**From:** [Redacted]  
**Sent:** 17 December 2008 22:05  
**To:** Planning  
**Subject:** S6/2008/2224/MA:Colesdale Farm, 26 Northaw Road West, Northaw

The site is in Green Belt and also the Northaw Common Parkland Landscape Character Area.

Drawing No 10
 ELEVATIONS ON
 A-A & B-B

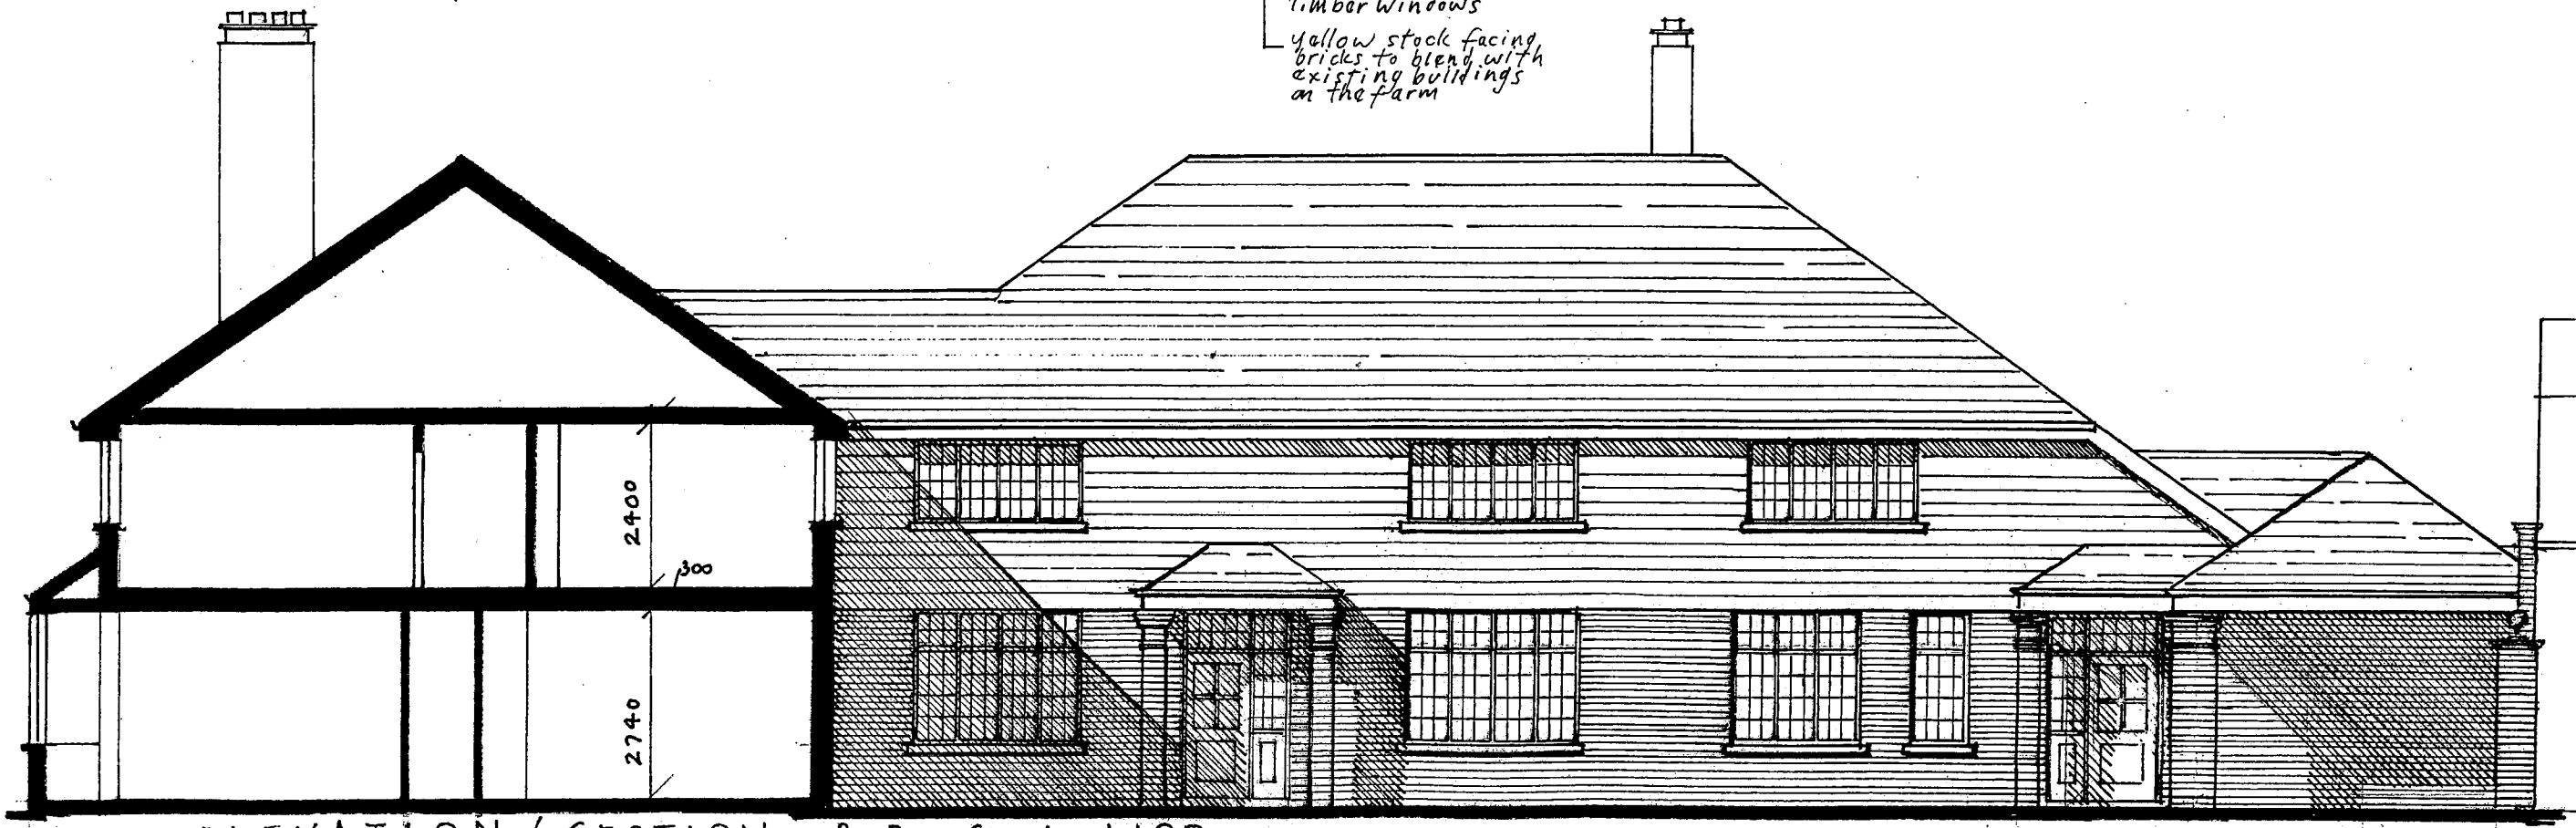
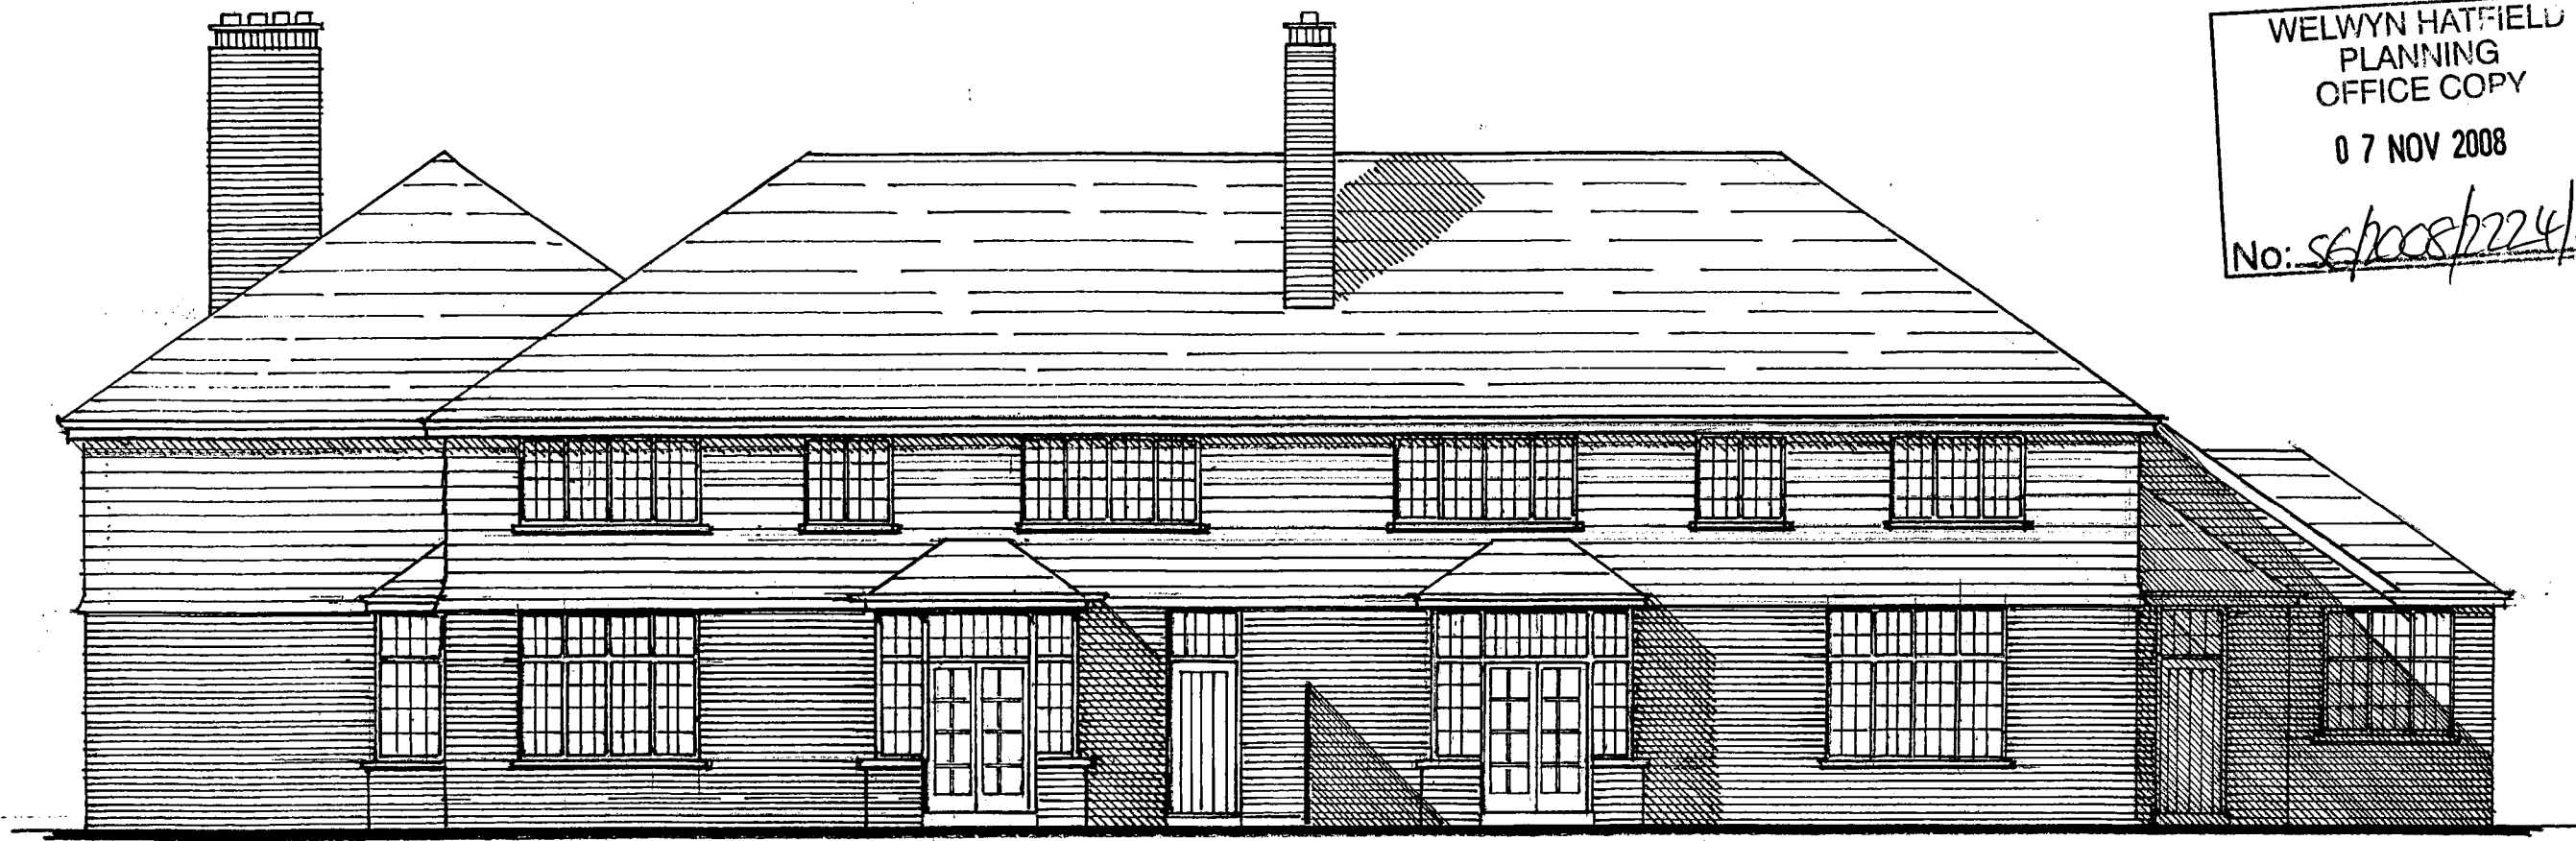
The Group comment that increase in number and height of dwellings in 'the close' for proposed development is retrograde step when compared with approved development – it is detrimental to visual impact, single-storey dwellings would blend in better with scenery.
